Our Ref: LU/333/19/NMA

Non material amendment following the grant of LU/201/16/RES as amended by LU/43/19/PL for plot boundary changes, minor alterations to elevations of houses & flats.

Windroos Nursery & Land Adjoining Worthing Road Littlehampton BN17 6LY

CLIENT	DANDARA
PROJECT	WINDROOS, LITTLEHAMPTON (2018)
TITLE	STREET ELEVATIONS D-D to F-F

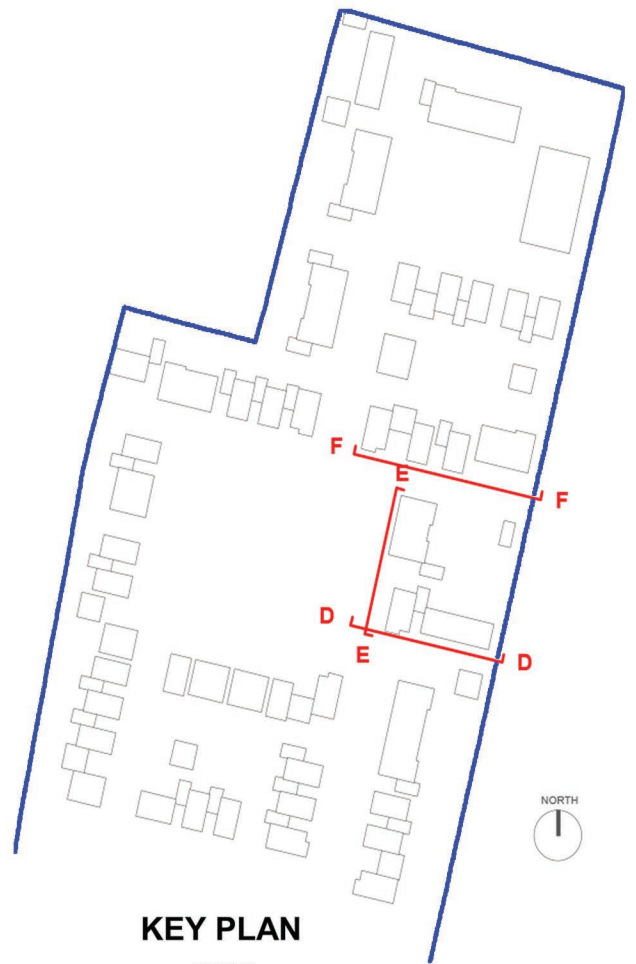
STREET SCENE ELEVATIONS

- Corbels added to front elevation.

- Stone Headers & Cills added to front elevation.
- Canopy roofs changed to 'L' shape.

CLIENT	DANDARA
PROJECT	WINDROOS 2018, LITTLEHAMPTON
TITLE	PROPOSED SITE PLAN

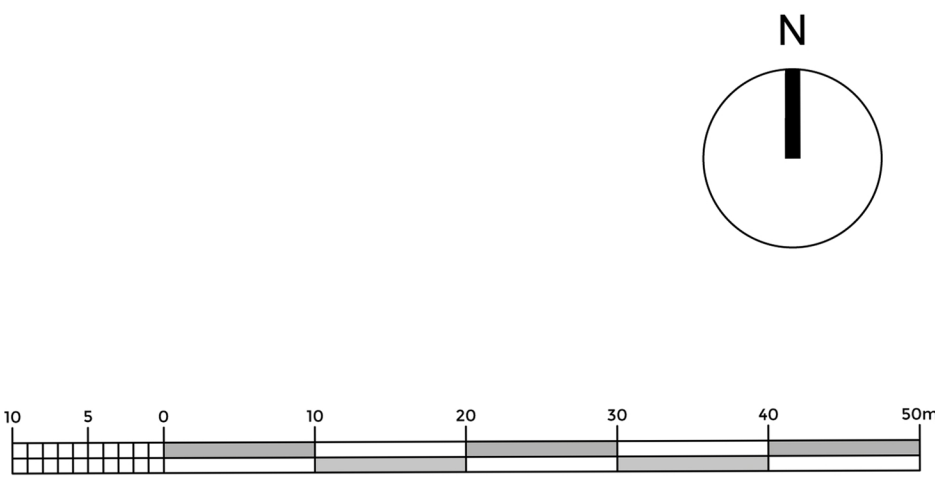
SITE PLAN:

- A former right of way on the east boundary and a former ransom strip to west and northern boundaries included into the plot boundaries.
- Rear access paths provided.
- Parking spaces to plots 5,6,7,8 & 41 re-aligned.
